CITY OF ALBUQUERQUE

**RE: La-Z-Boy Center
Grading and Drainage Plan
Engineer's Stamp Date: 08/17/22
Hydrology File: E17D005**

Based upon the information provided in your submittal received 08/17/2022, the Grading & Drainage Plan is not approved for grading and paving permit until the following comments are addressed:

Sheet No.
C-100

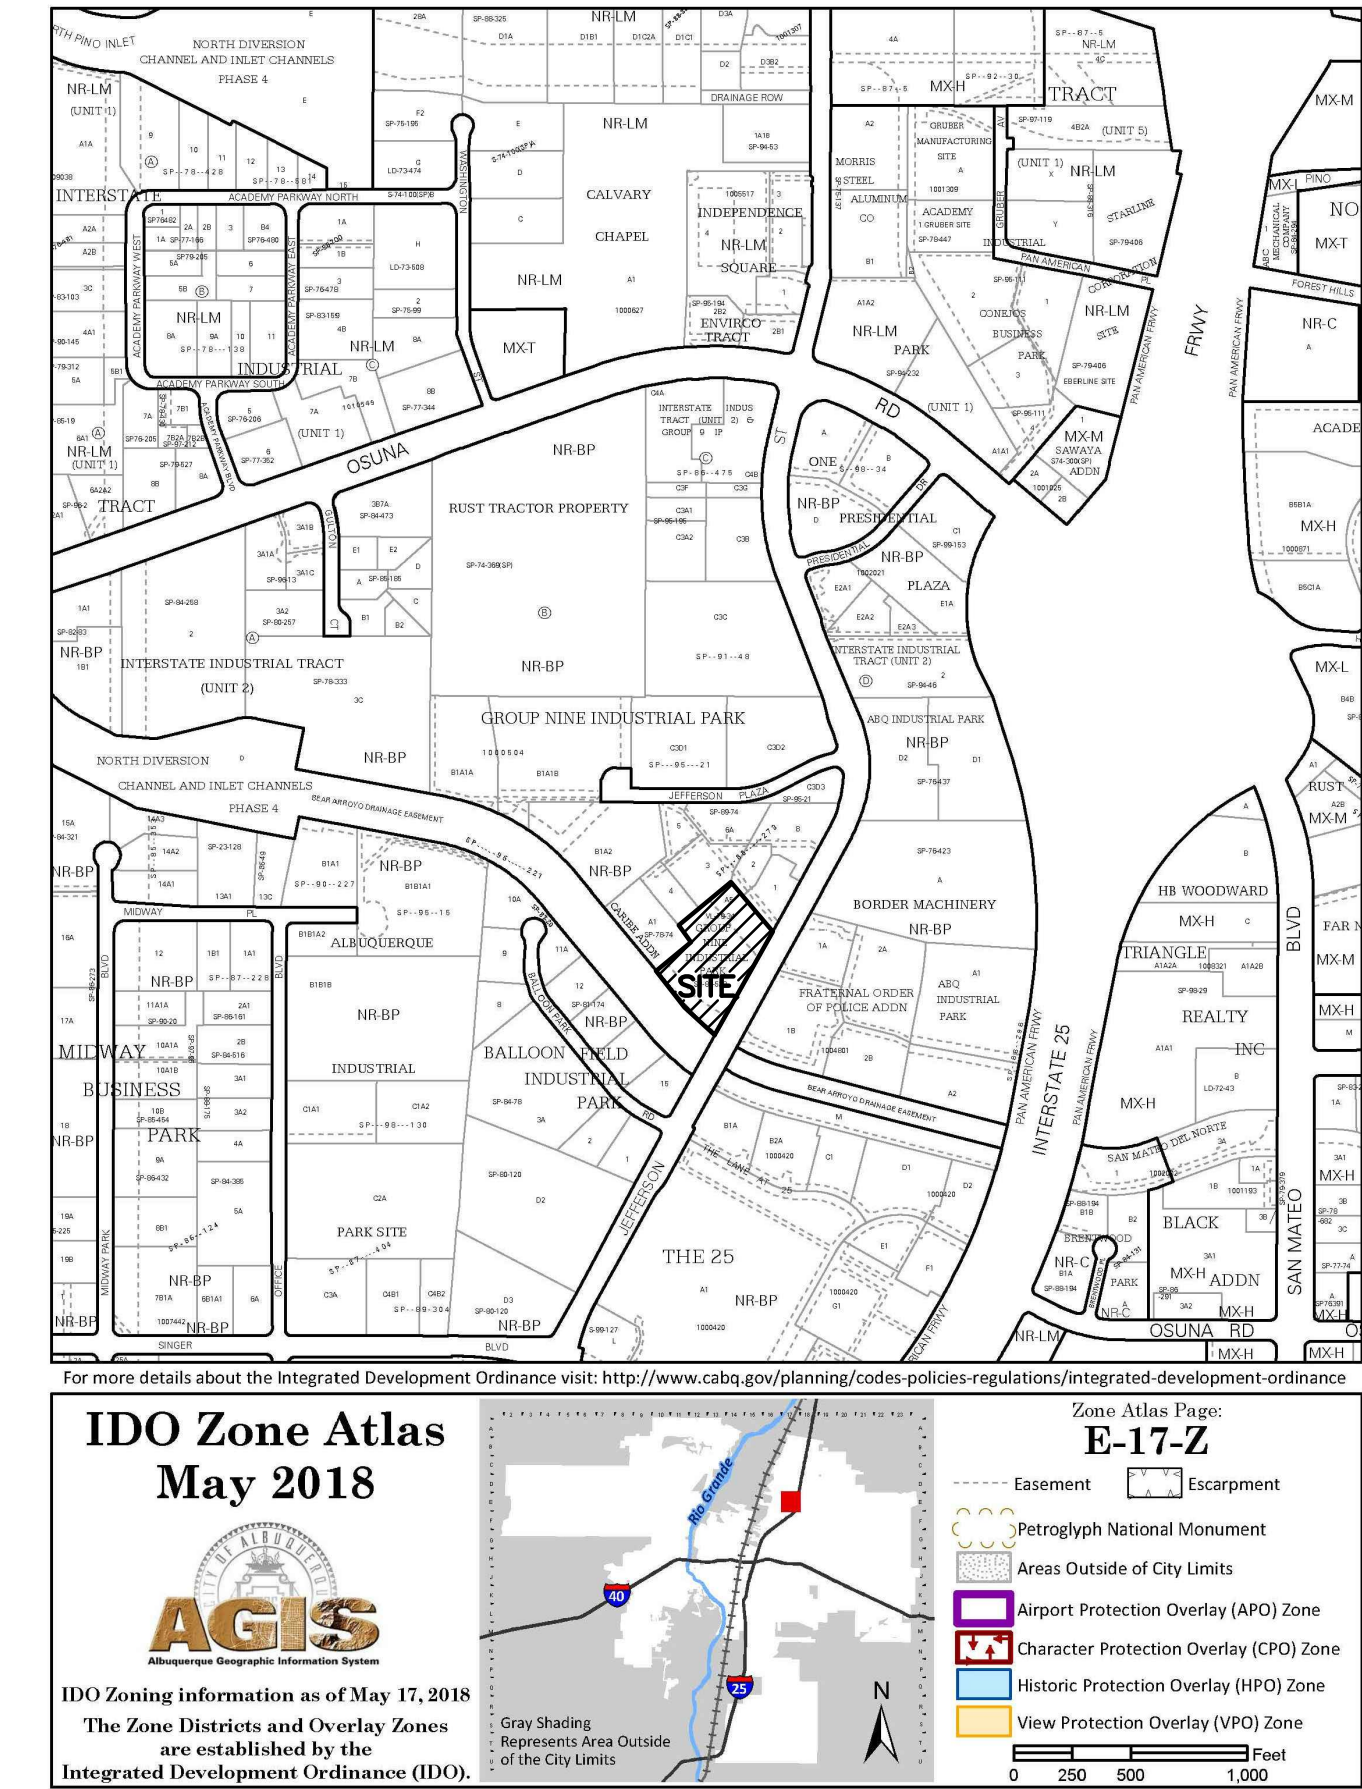
1. Provide for stormwater quality for the proposed impervious area: 0.26" of runoff. Hydrology realizes the area was previously impervious, but when construction is to occur on existing sites stormwater quality must be provided. A pond or similar can be built or the attached waiver can be filled-out and submitted
2. Since the site abuts the Bear Canyon Arroyo, AMAFCA approval is required prior to City approval. AMAFCA's requirements may affect the use of the waiver mentioned in paragraph 1.
3. Show the outfall from the site (inlet and pipe) to the arroyo and label the Bear Canyon Arroyo.
4. In the existing conditions paragraph, please state "The sites drains to the Bear Canyon Arroyo via an inlet in the southwest corner and a pipe into the arroyo" or similar.
